Tuck O'Brien  
City Planning Director, Planning Division

Project Name: **India Newbury Residences** Project ID: 2016-052  
Address: 62 India Street CBL: 028 P008, P009, P015, P019, P020  
Applicant: India Newbury Residences, LLC  
Planner: Caitlin Cameron

On May 24, 2016, the Planning Authority approved with conditions a Level II site plan for India Newbury Residences for 29 residential units, 3 retail bays, and structured parking at 62 India Street. The decision is based upon the application, documents, and plans as submitted by India Newbury Residences, LLC and prepared by Sebago Technics, Civil Engineers, and Mark Mueller Architects. The proposal was reviewed for conformance with the standards of Portland's site plan ordinance.

AREA CALCULATION:

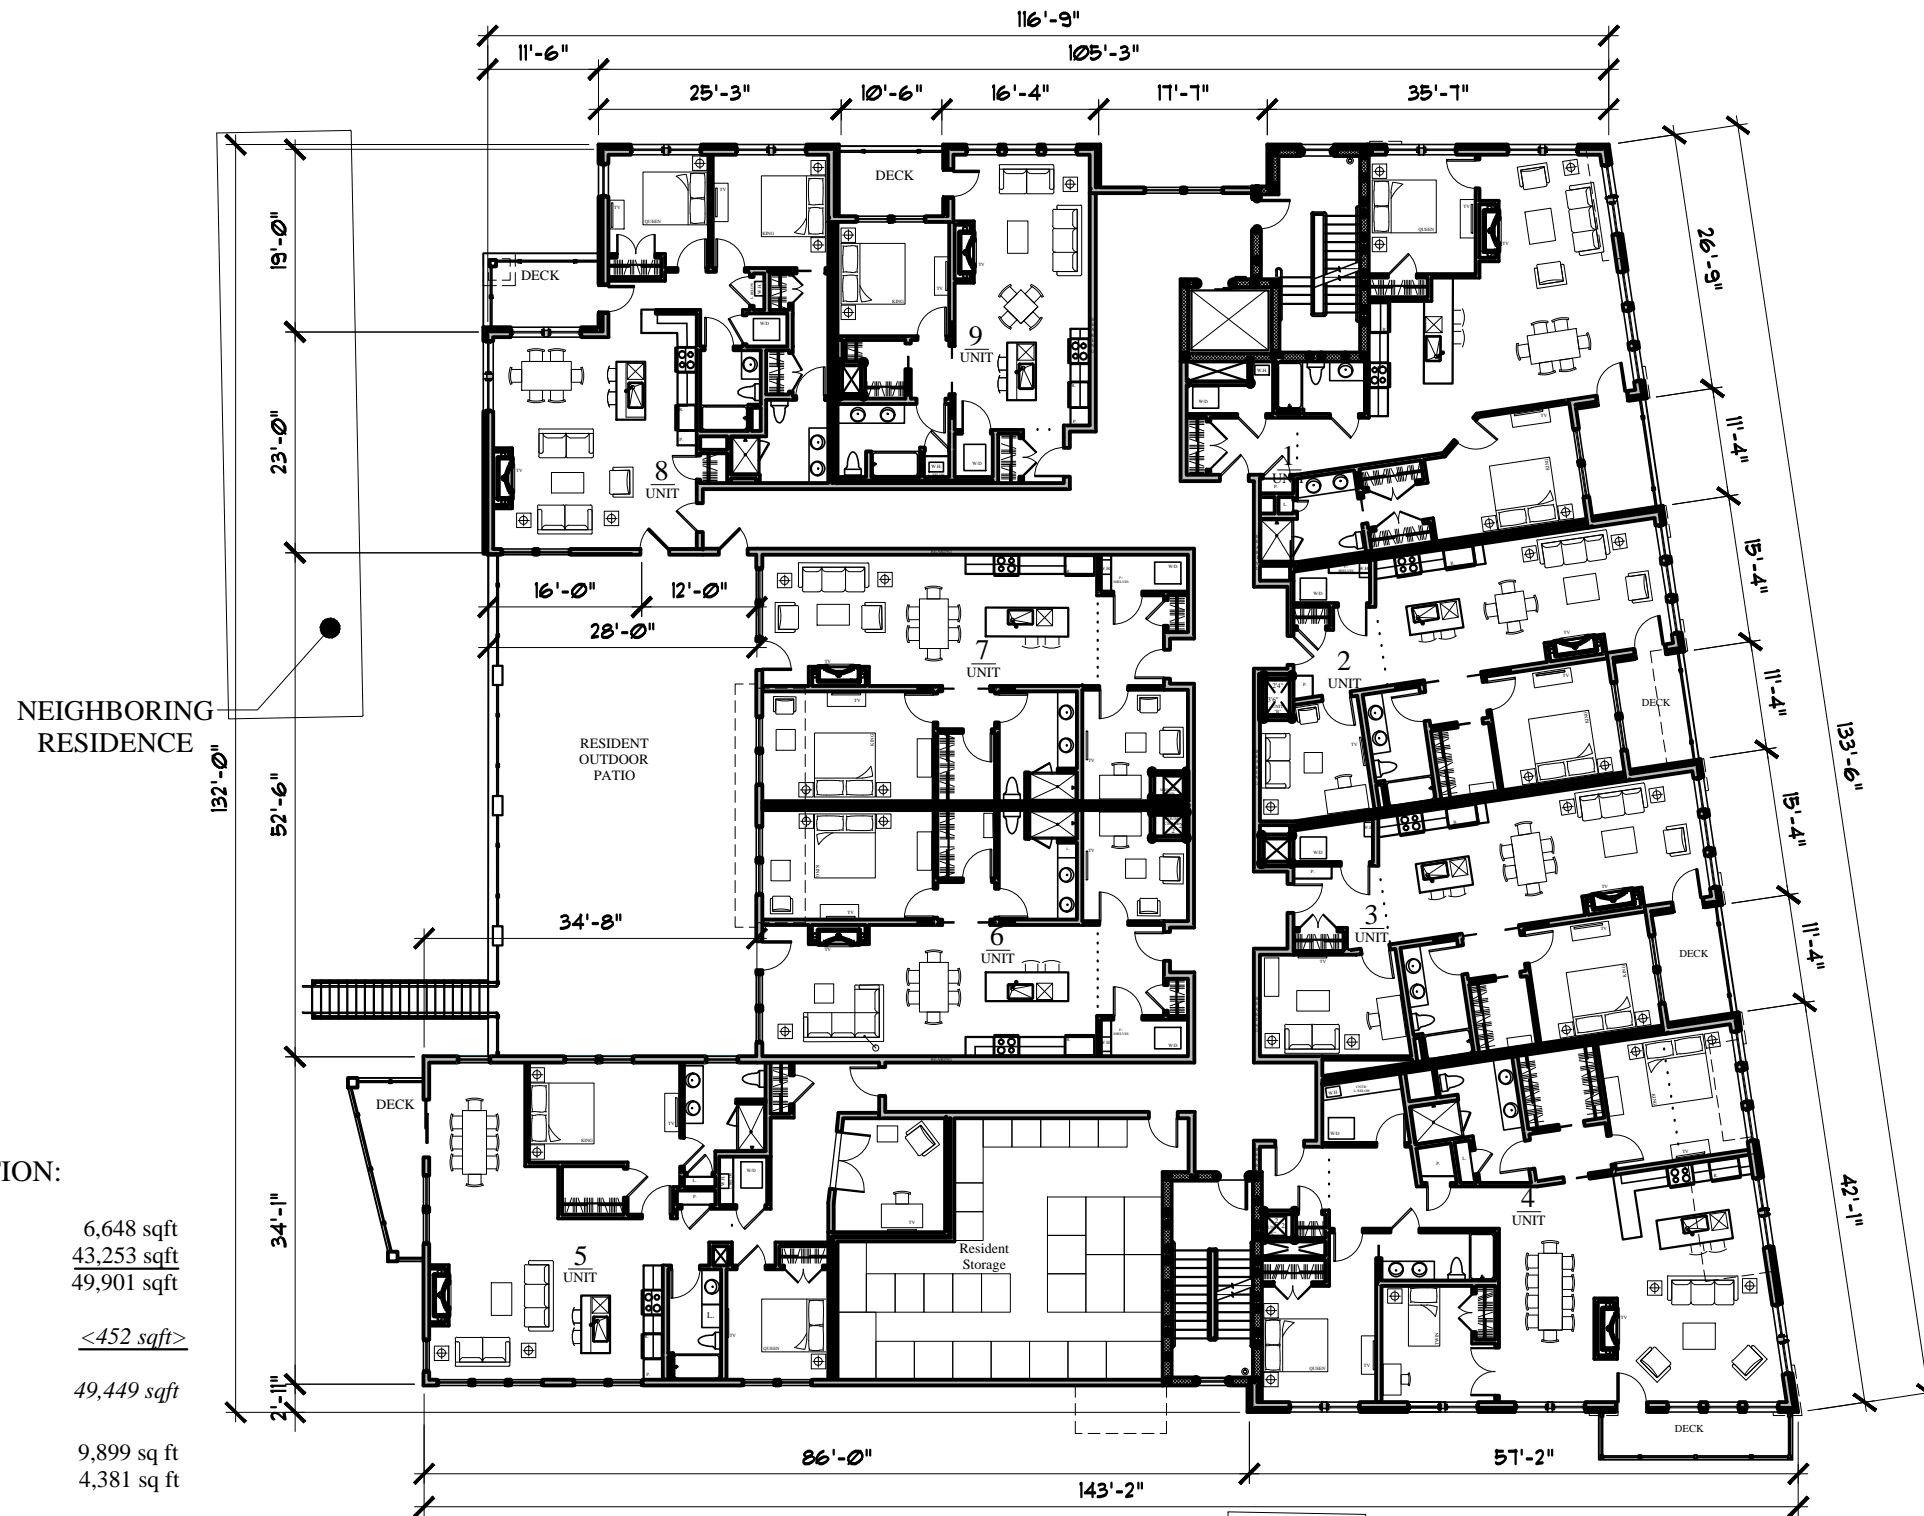
1. The final design of the sidewalk including cross slope, curb extension, and street tree well shall be revised and submitted to staff for final approval.
2. The applicant shall provide revised drawings showing correct area calculations.

EXISTING CONDITIONS PLAN
 OF:
 50-62 INDIA STREET
 PORTLAND, MAINE
 FOR:
 INDIA NEWBURY RESIDENCES, LLC
 35 ST. STE. 1078
 PORTLAND, ME 04108

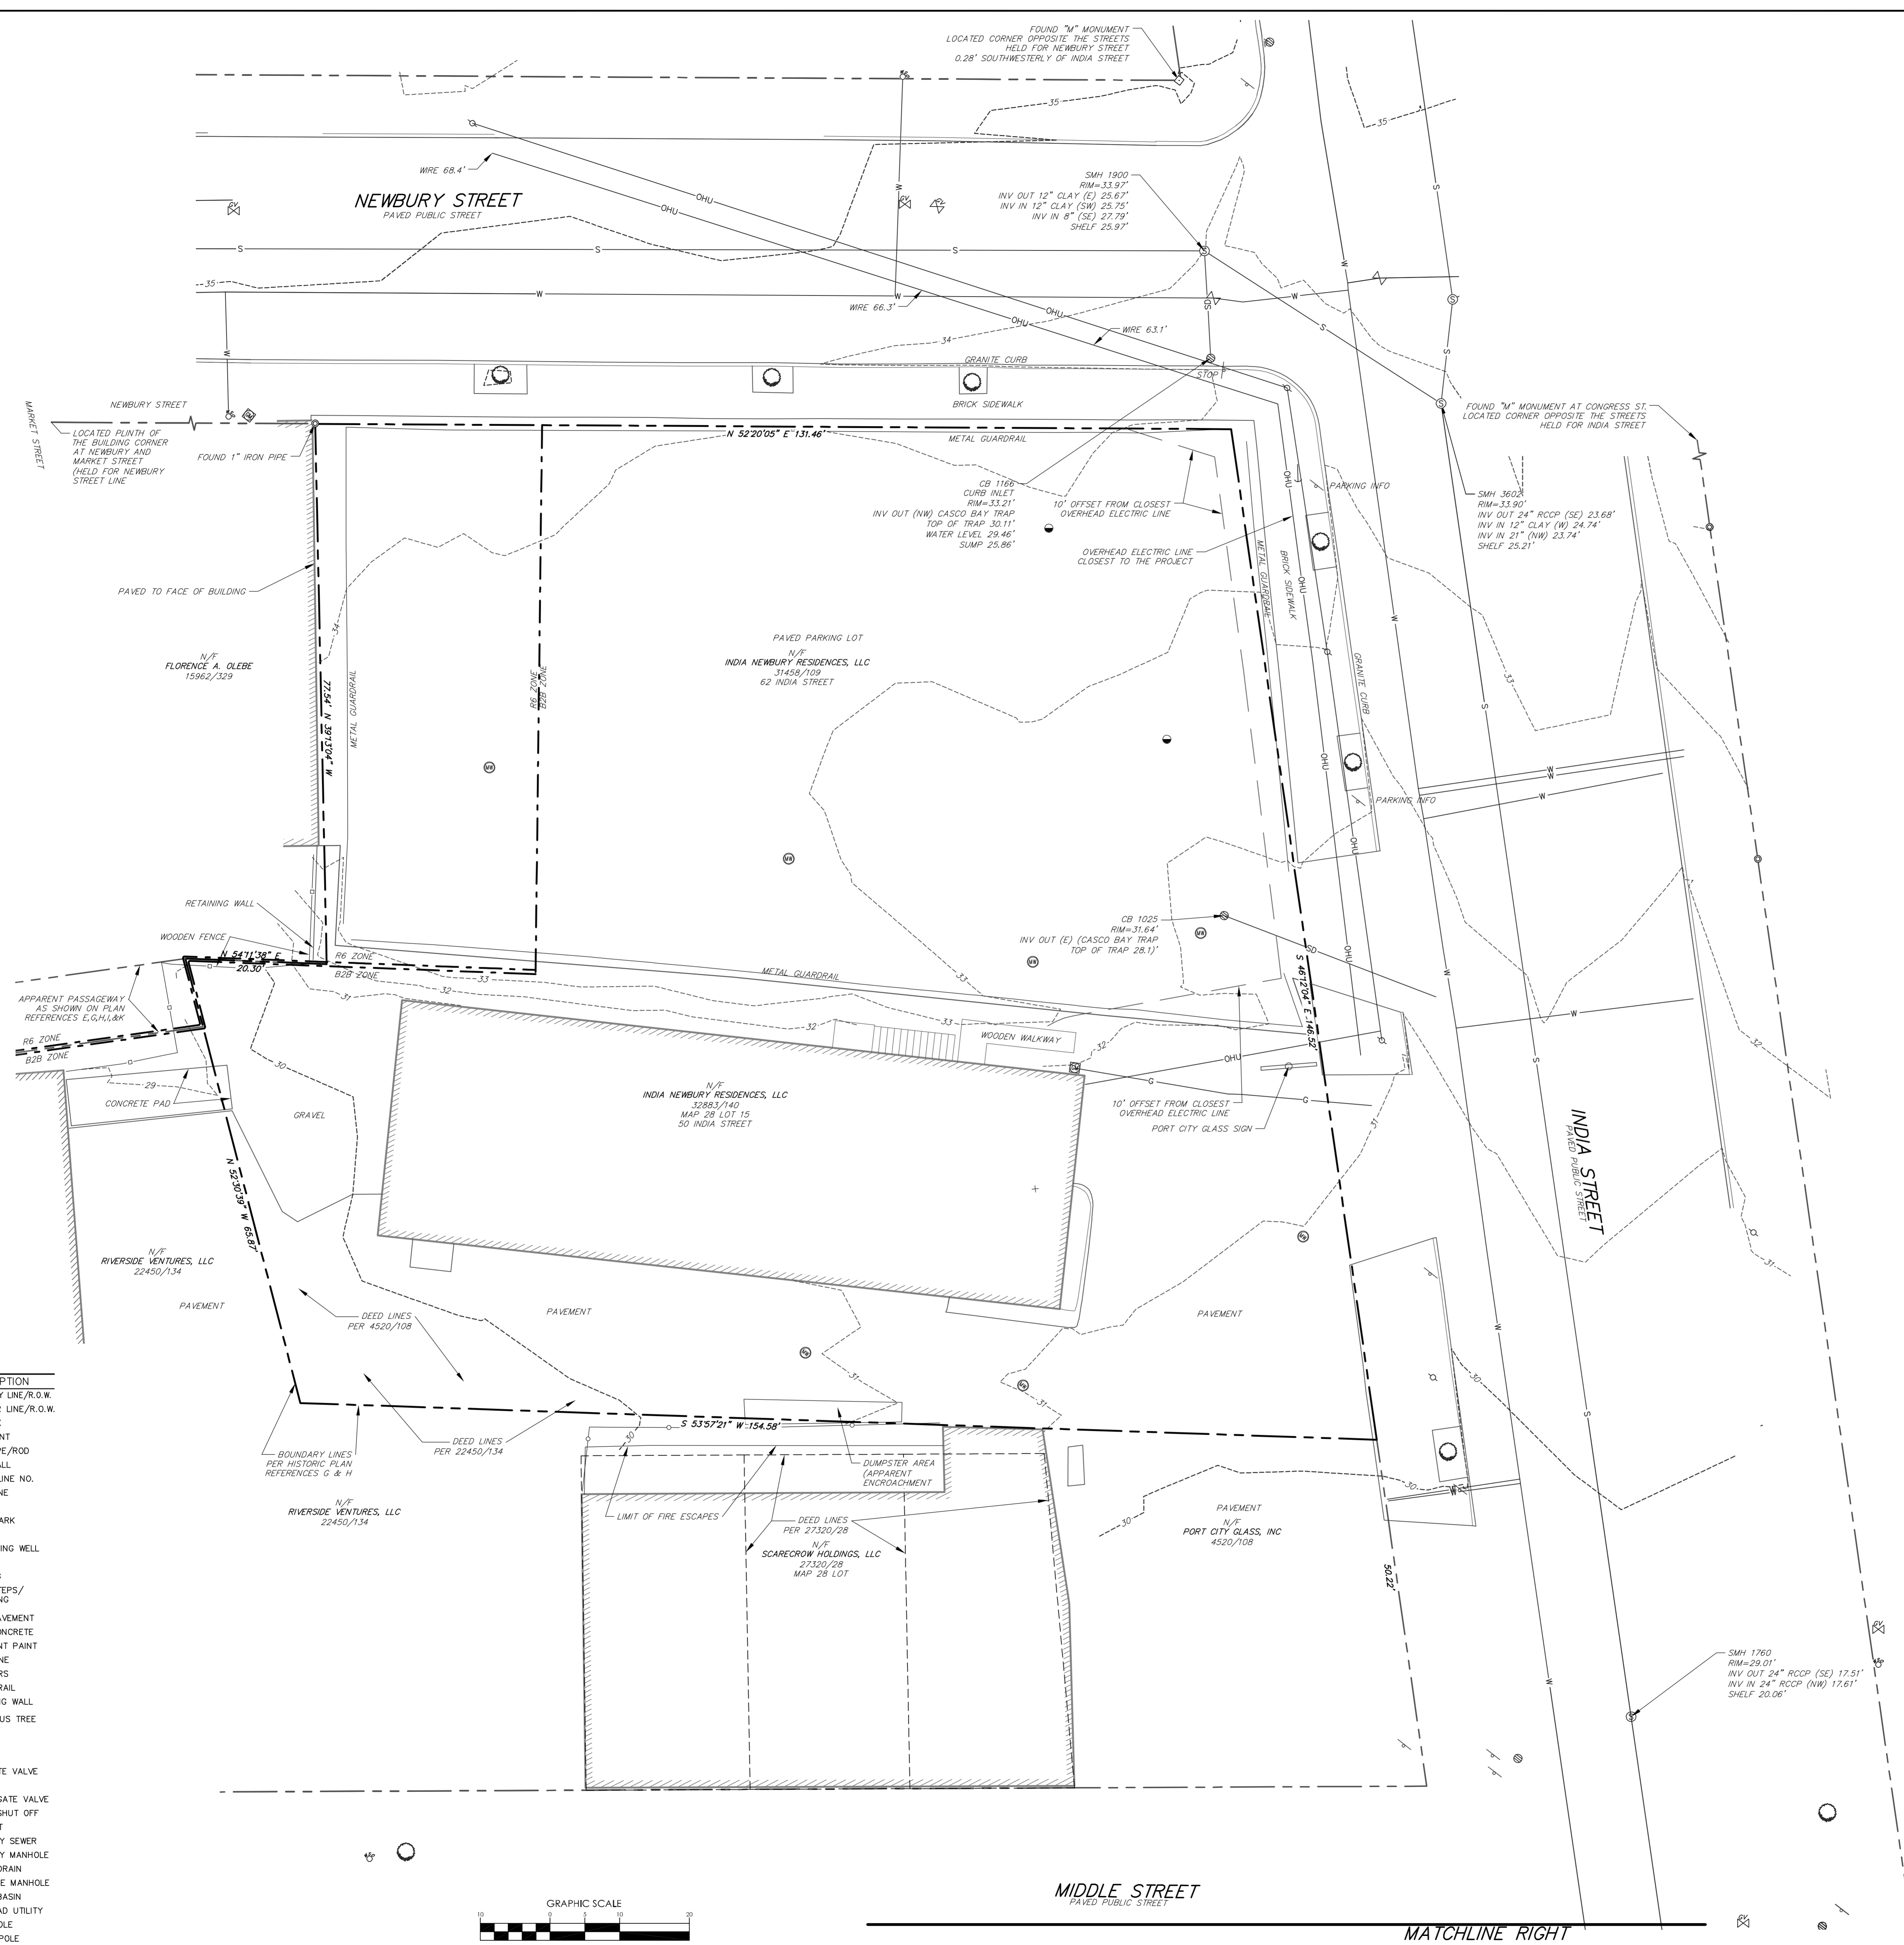
“The proposed three foot offset monument center needs to be at the intersection of the three foot offset lines; on the plan the corner of the monument is shown at the intersection of the three foot offset lines.”

PRECAST SEWER MANHOLE
NOT TO SCALE

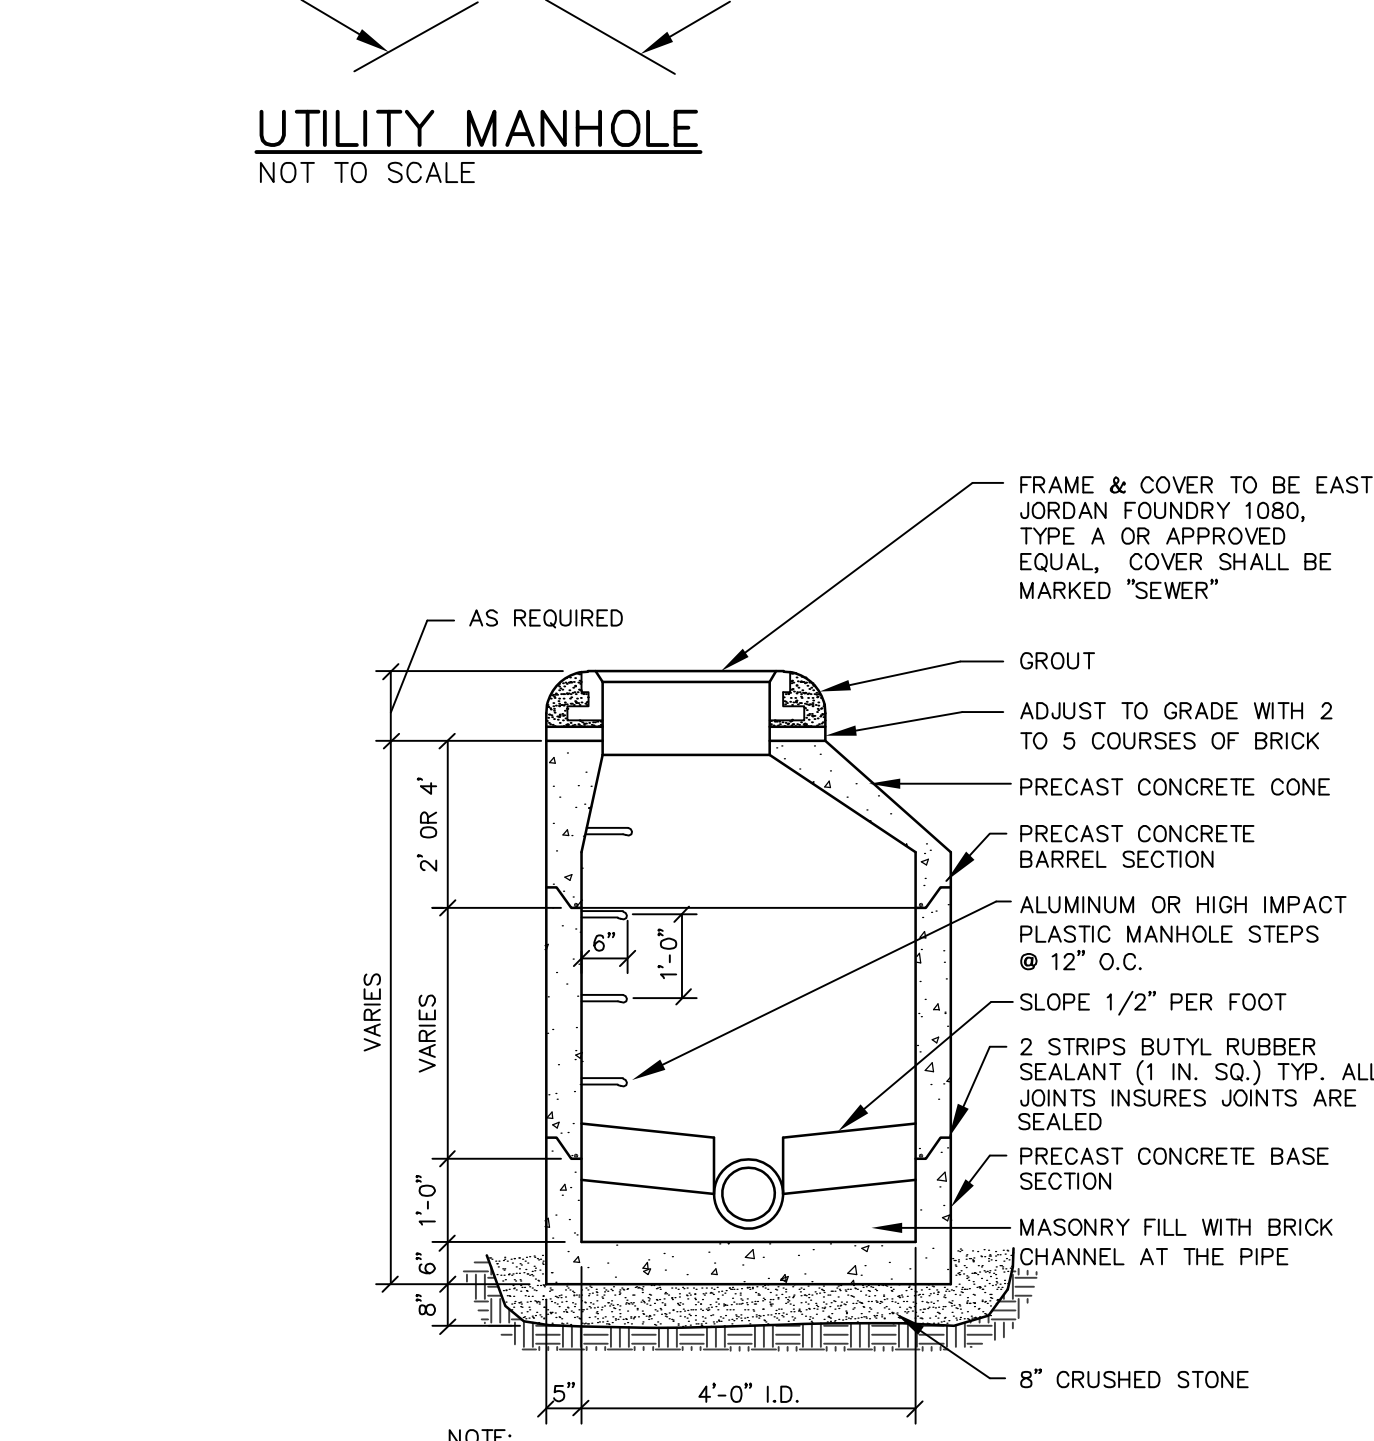
3. The applicant shall provide revised drawings showing correct dimensions for final review and approval by the Planning Authority.
4. The final Site Plan shall be stamped by a professional engineer.
5. The Precast Sewer Manhole Detail shown on Sheet 11 should comply with Figure II-1 of the City of Portland Technical Manual for work within the City right-of-way.
6. The applicant is required to provide a final Construction Management Plan for review and approval by the Department of Public Works and the Planning Authority.
7. The applicant shall document that the parking spaces meet ADA requirements.
8. Conditions of approval associated with the Historic Preservation Certificate of Appropriateness shall be reflected in the final Site Plan drawing set.

- 1) The Site Plan has been stamped by a landscape architect and has not been stamped by a professional engineer. In accordance with Section 14-527, sub-section (f) of the City of Portland Land Use Ordinance, the final Site Plan must be stamped by a professional engineer.
- 2) The Precast Sewer Manhole Detail shown on Sheet 11 should comply with Figure II-1 of the City of Portland Technical Manual for work within the City Right-of-Way.
